26 September 2019

SF2018/193074; WST18/00088/04

**SSD-9358: Lots 2 DP 586990 and 21-23 DP 1174848; 330-362 Logans Lane, Narrabri
Proposed 120 MW Solar Farm 'Silverleaf'**

FIGURE 3-1

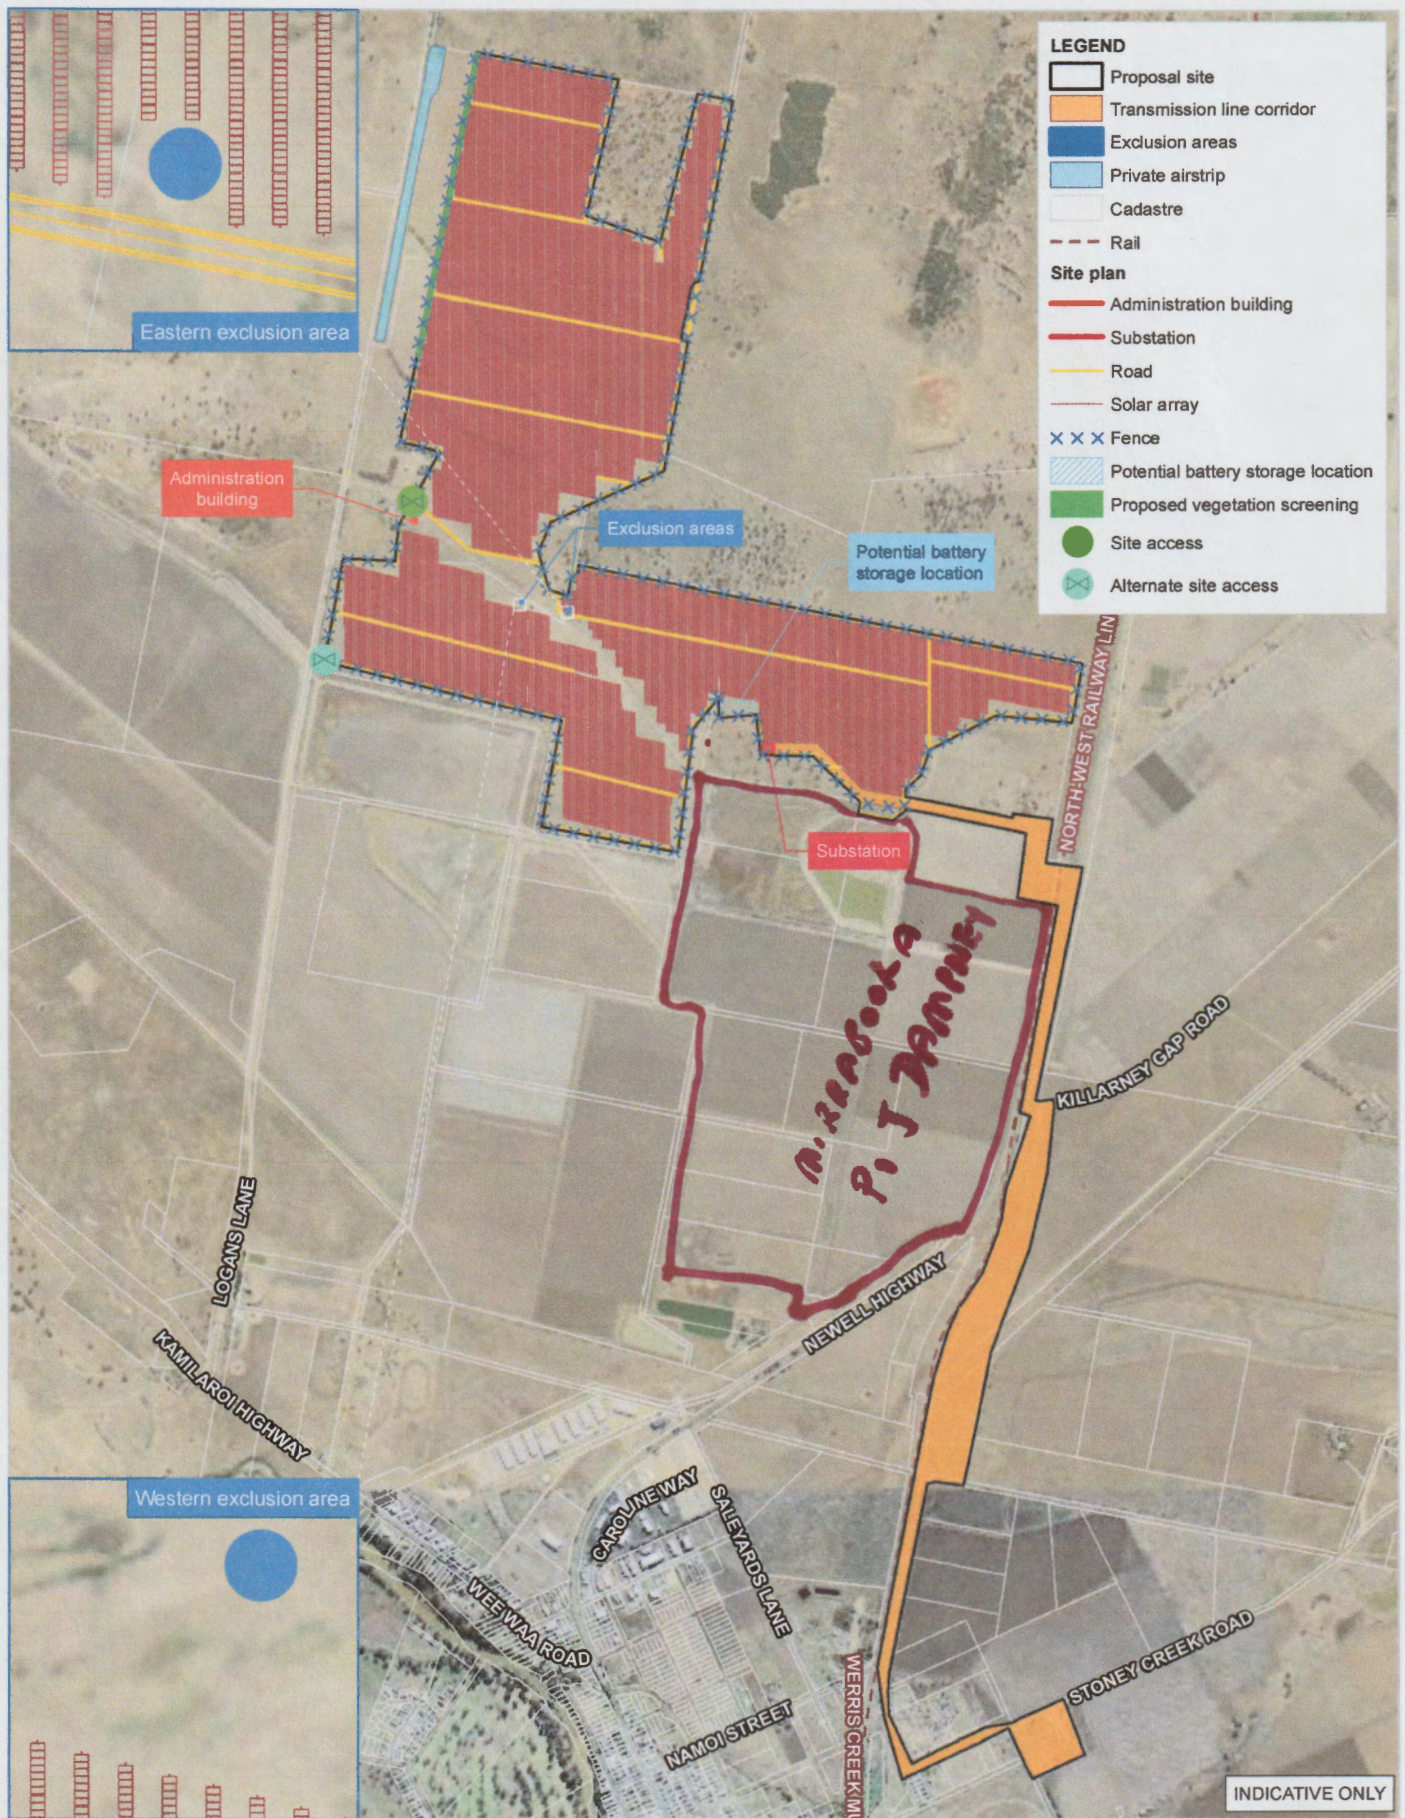
- The site has direct vehicular access to the Newell Highway to the east, and the Kamilaroi Highway (via Logans Lane) to the southwest. As noted in the SEARs submission, Roads and Maritime does not object to a single vehicular access from the intersection of the Kamilaroi Highway (via Logans Lane). The Newell Highway access is not to be used by development traffic but is to remain open for general agricultural use.

- Prior to commencement of onsite solar farm construction, the proponent is required to upgrade the intersection of Kamilaroi Highway and Logans Lane to the satisfaction of Roads and Maritime including:

- Prior to construction, detailed designs for works within the classified road reserves will need to be submitted and approved by Roads and Maritime for concurrence pursuant to Section 138(2) of the *Roads Act 1993*. This includes transmission line work within the Newell Highway (HW17 / A39) and Killarney Gap Road (MR133), and road intersection work within the Kamilaroi Highway (HW29).

- Above-ground structures in roads including transmission line poles or towers are to be located as per Roads and Maritime's Requirements for Overhead Power Lines (see copy attached), and:

- Be located as far as practicable from the road, and outside the clear zone as set out in *Austrroads Guide to Road Design Part 6: Roadside Design, Safety and Barriers*, which at this location on the Newell Highway is 10m from the edge of traffic lane. If the road reserve is not wide enough to locate poles outside the clear zone, it may be necessary to design the poles to be frangible or otherwise locate poles within private property.
